Application H12-0949-25
Location Lutton Marsh Methodist Church Guys Head Road Lutton Marsh PE12 9NP
Proposal Change of Use, Conversion & Extension to Create a Single Dwelling

Name Greg Watkinson
Address Conservation Officer

Date Submitted 23-10-25
For/Against Objections

Drawing
FLOOR PLANS - PROPOSED
ELEVATIONS - PROPOSED
SITE PLAN - PROPOSED

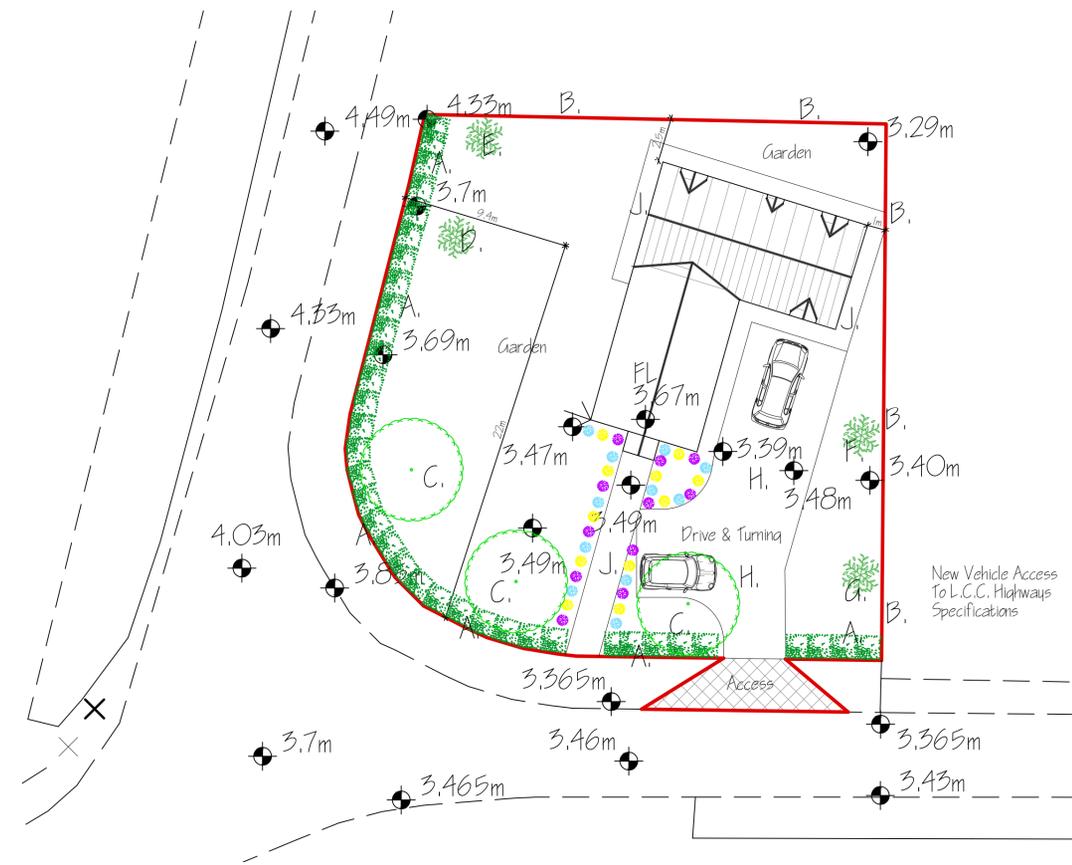
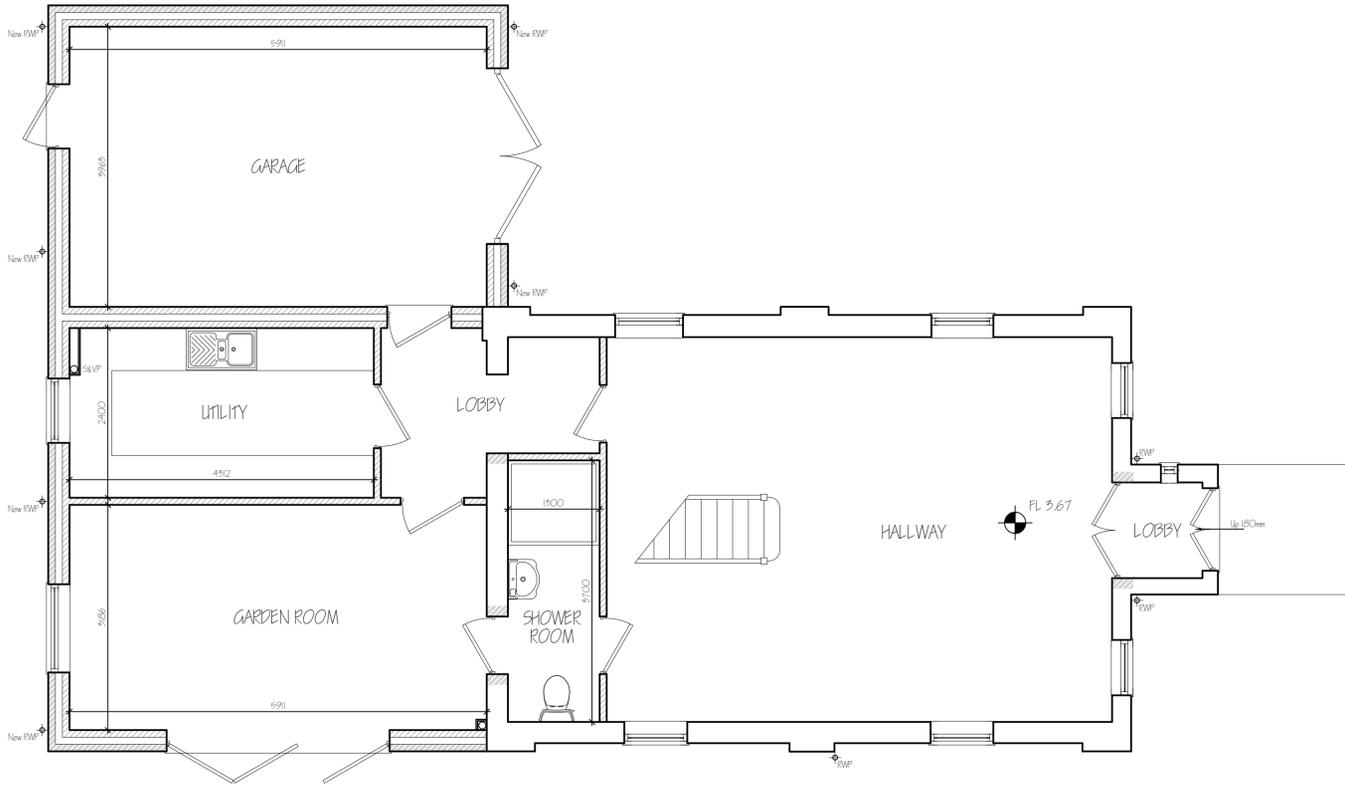
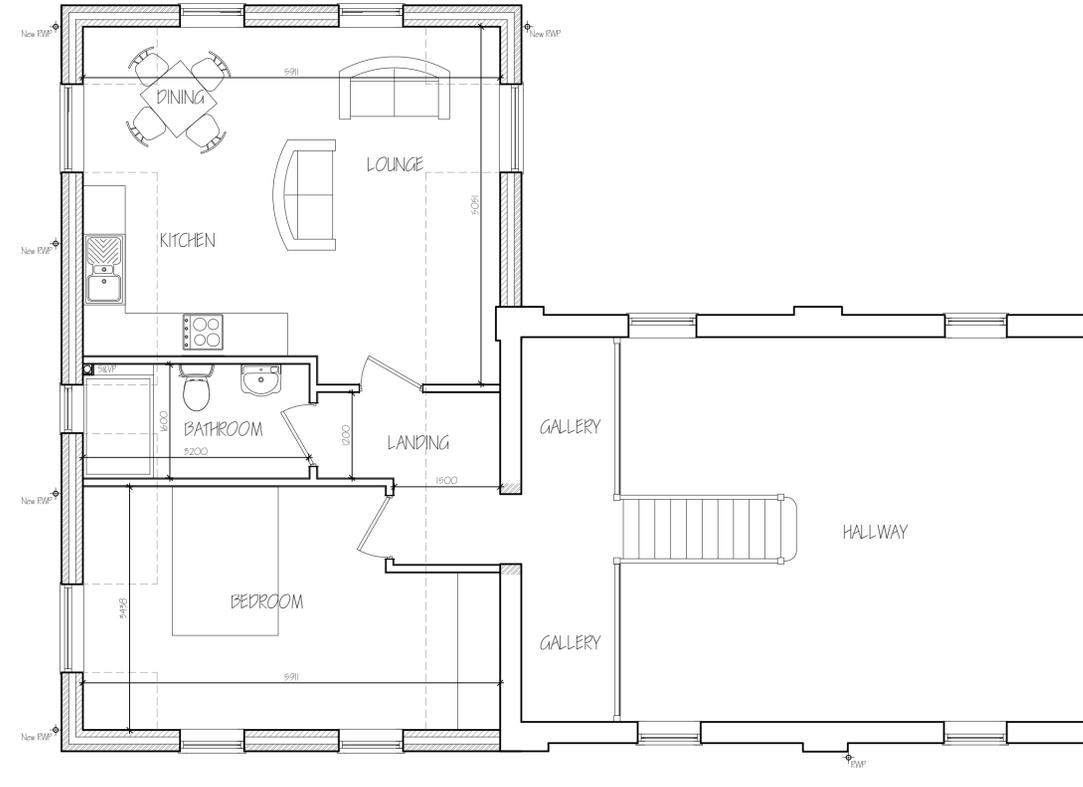
In this instance, the proposed rear and side extension to form the bulk of the proposed residency would fundamentally alter the character of the building and is of such a scale as it would almost entirely crowd out appreciation of the original building. Per para. 216 of the NPPF above, a balanced judgement regarding the scale of harm is required. In this instance, I consider that the proposal neither conserves nor enhances the NDHA or its setting and therefore that the harm to the original building to be so complete as to represent grounds for refusal, such is its weight in the balance.

Extensions to an NDHA such as this should seek to be much reduced in scale or bear as lightweight an impact upon what original structure remains on site. This may, for instance, take the form of a form of construction to the side(s) of the extant building with a glazed link offering visual demarcation between the extant and the new.

I cannot support the proposal as it currently stands.
